Re: Stakers Farm, Yapton

Further to your recent email enquiry, we offer the following comments for your consideration.

Permavoid Cover Depth

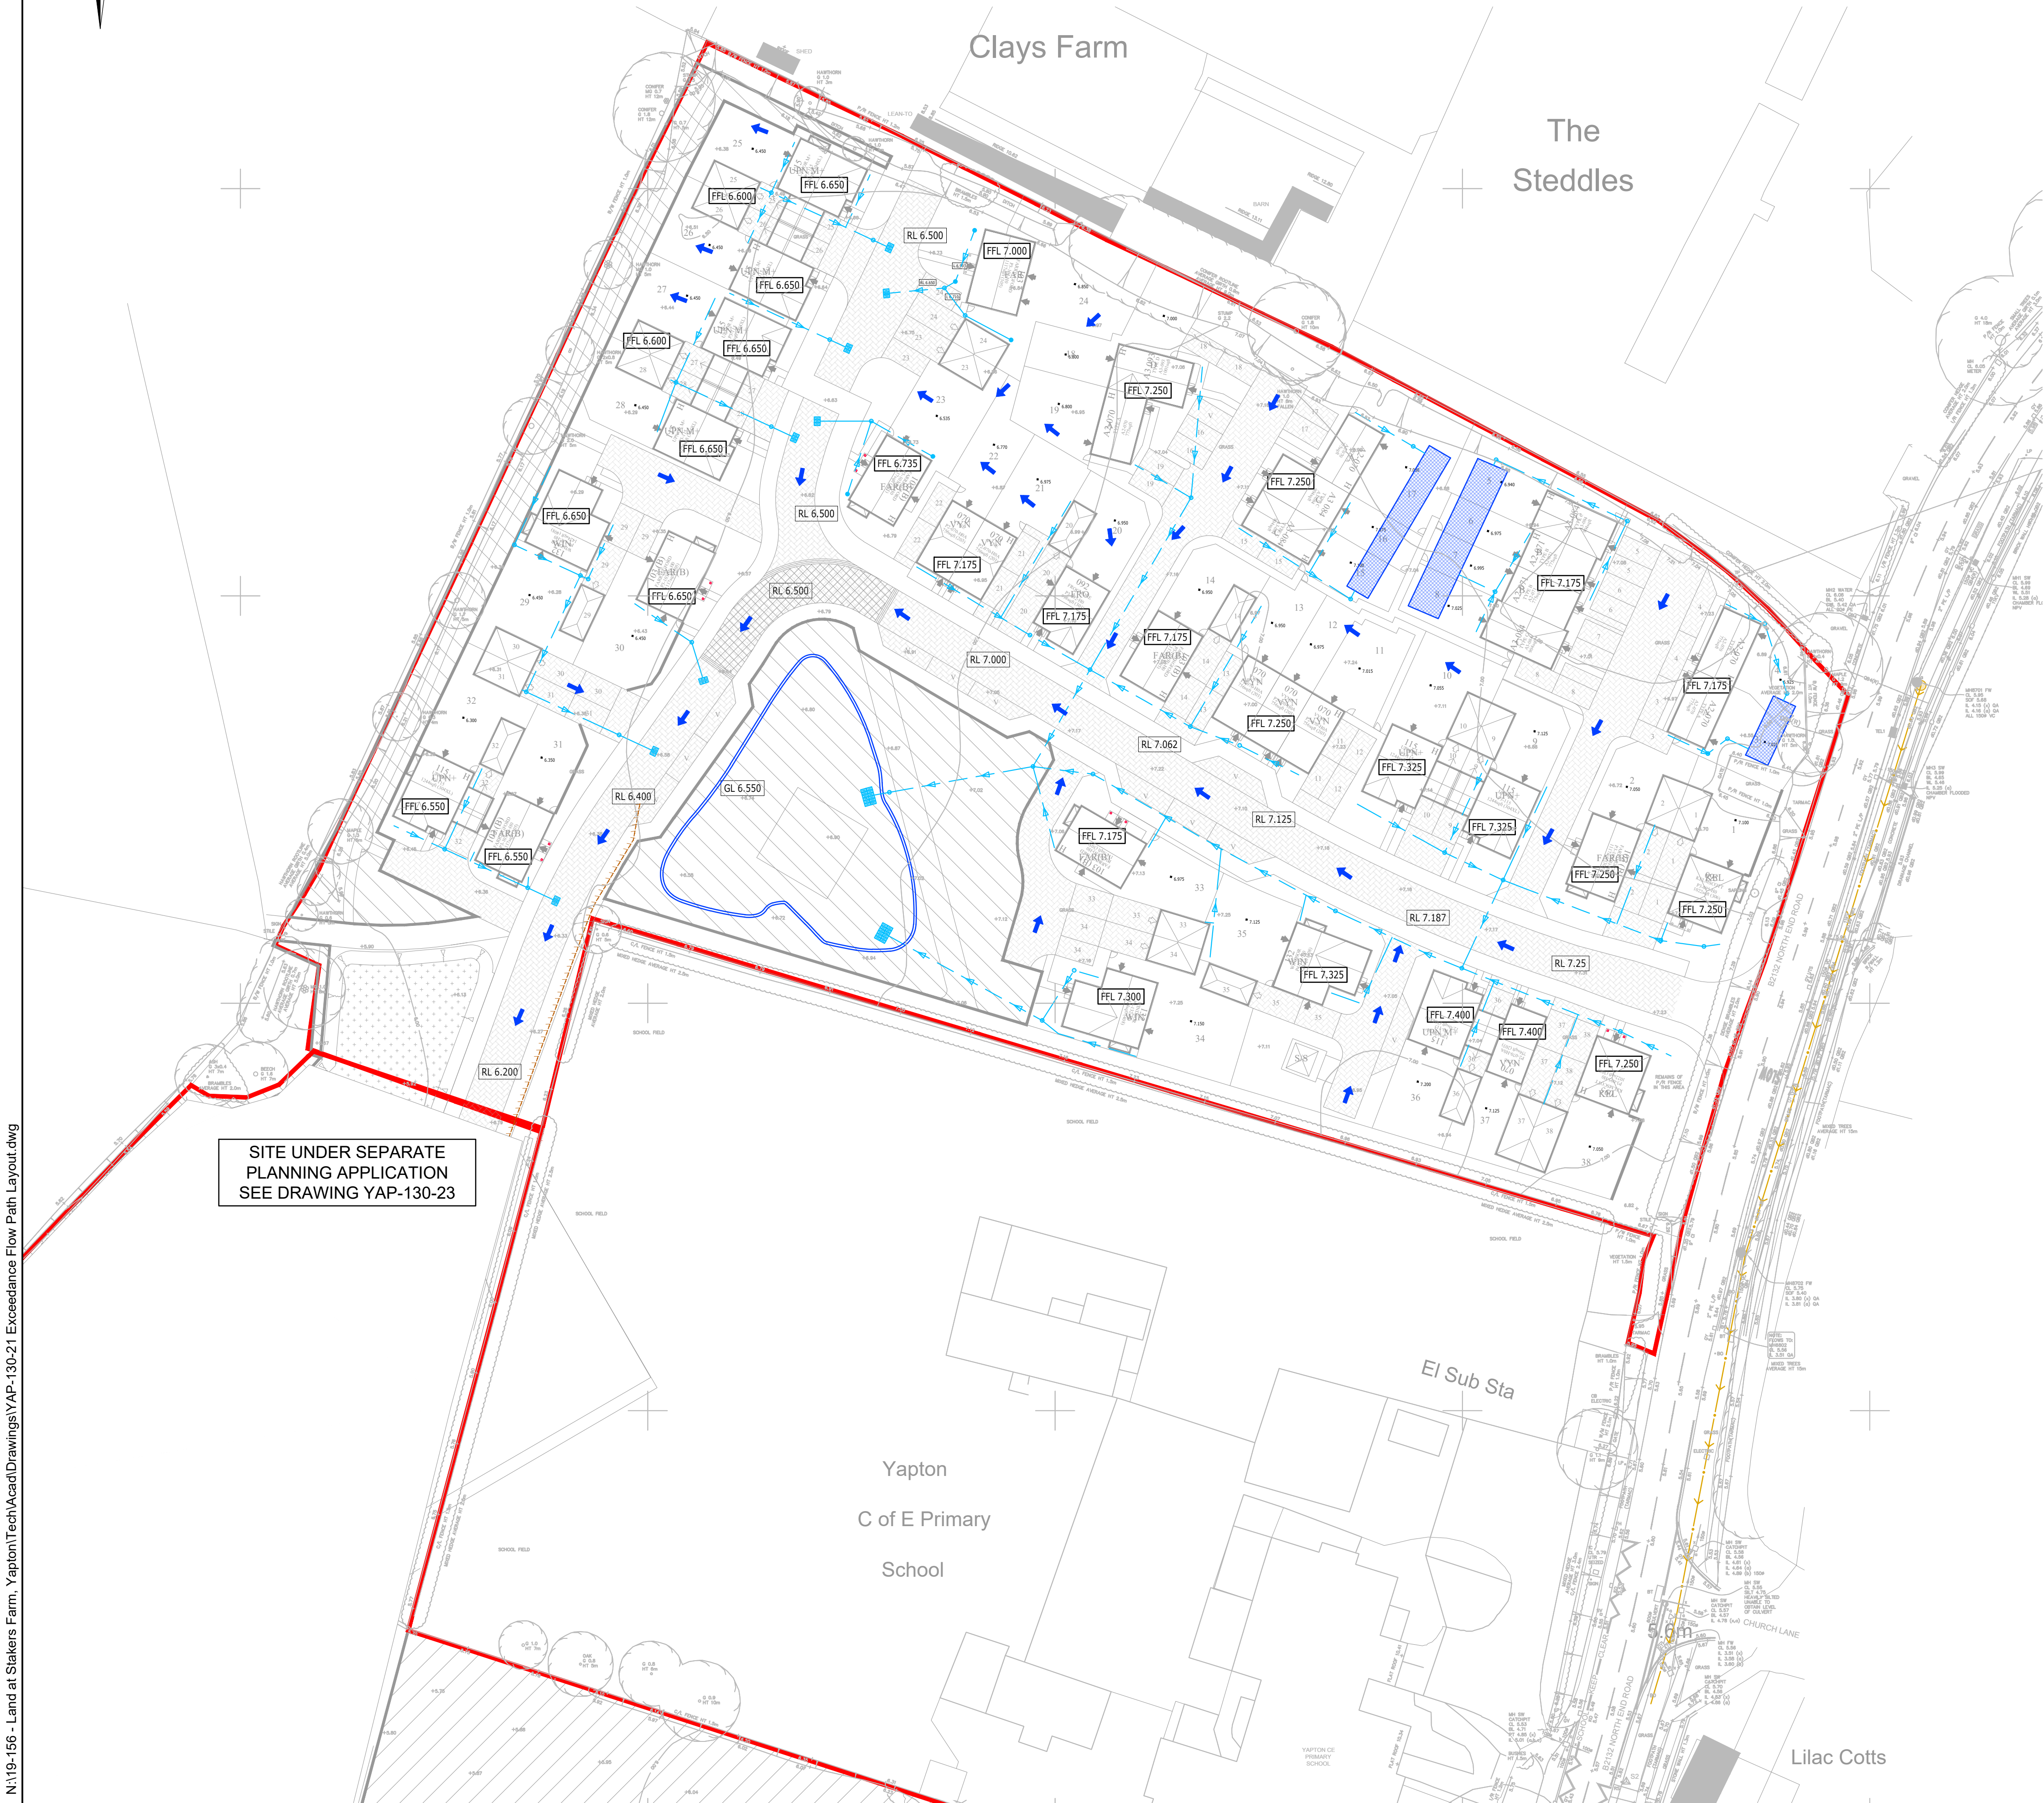
We propose the diffuser unit that discharges into the infiltration basin located in public open space (POS) to effectively manage a peak flow of 80l/s will have to be of a radial design (see attached sketch layout). This will have 6no. legs extending from a dissipation chamber. Calculations for performance are provided below.

It is proposed that the dissipation chamber will be Ø1200mm with a 300mm sump at IL = 5.720 and CL = 6.550. The chamber would be provided with Ø225mm spigots and a GRP open grating removable cover.

ROAD TYPE 4 CONSTRUCTION
PERMEABLE BLOCK PAVING

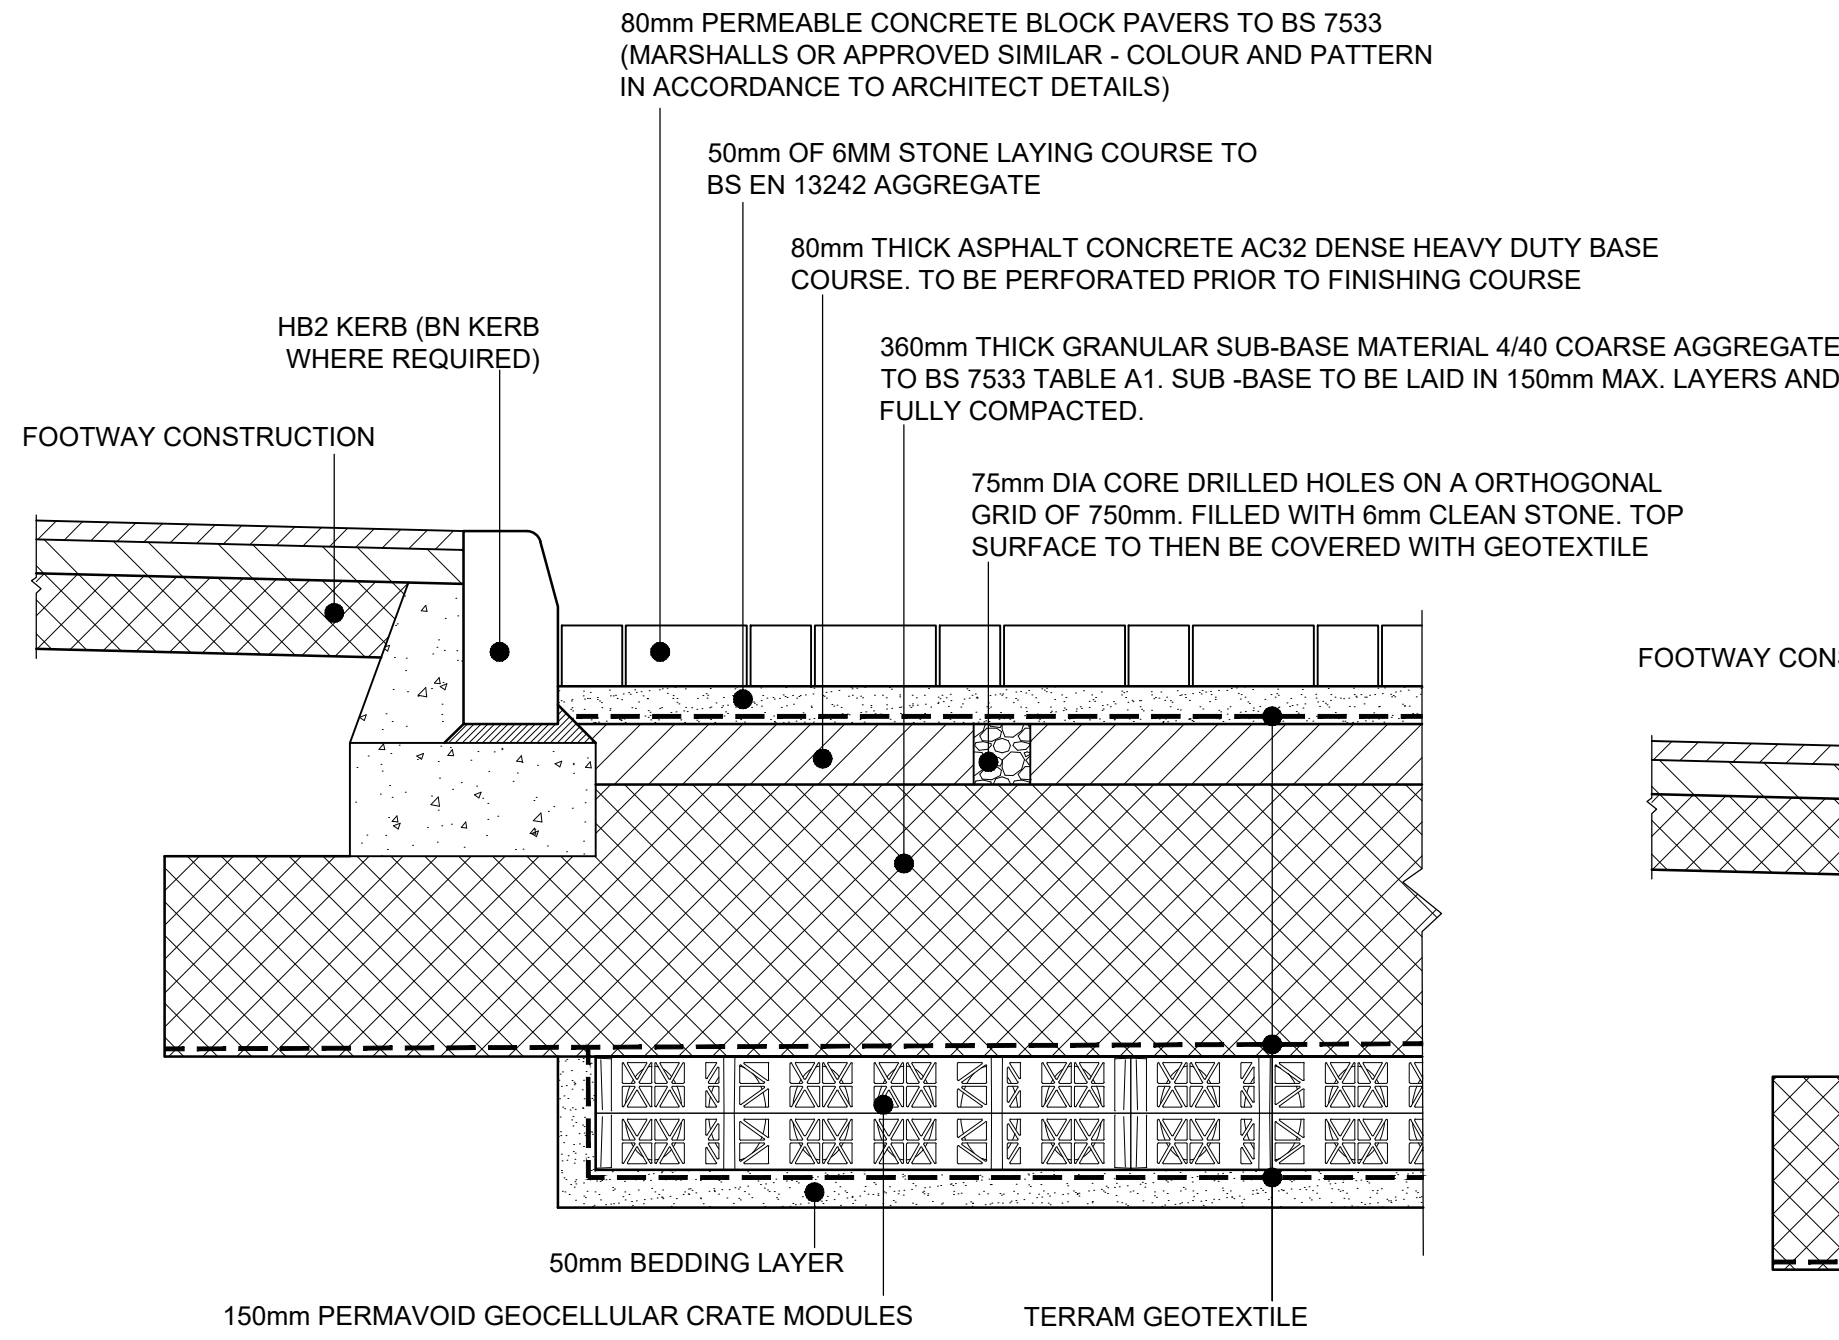
Subject to a minimum CBR at formation of 5% or greater, a minimum cover of 260mm is acceptable based on the two road construction scenarios you describe in your email dated 03/09/2020 and summarised below.

- Road type 3 and 4 - 150mm thick Permavoid, overlaid with 330mm-340mm of 4/40 granular material, overlaid with 80mm asphalt concrete during construction stage and then asphalt concrete would be core drilled and finished with 50mm bedding and 80mm permeable block paving.
- Road type 2 - 235mm thick Permavoid, overlaid with 180mm of 4/40 granular material, overlaid with 80mm asphalt concrete during construction stage and then asphalt concrete would be core drilled and finished with 50mm bedding and 80mm permeable block paving.
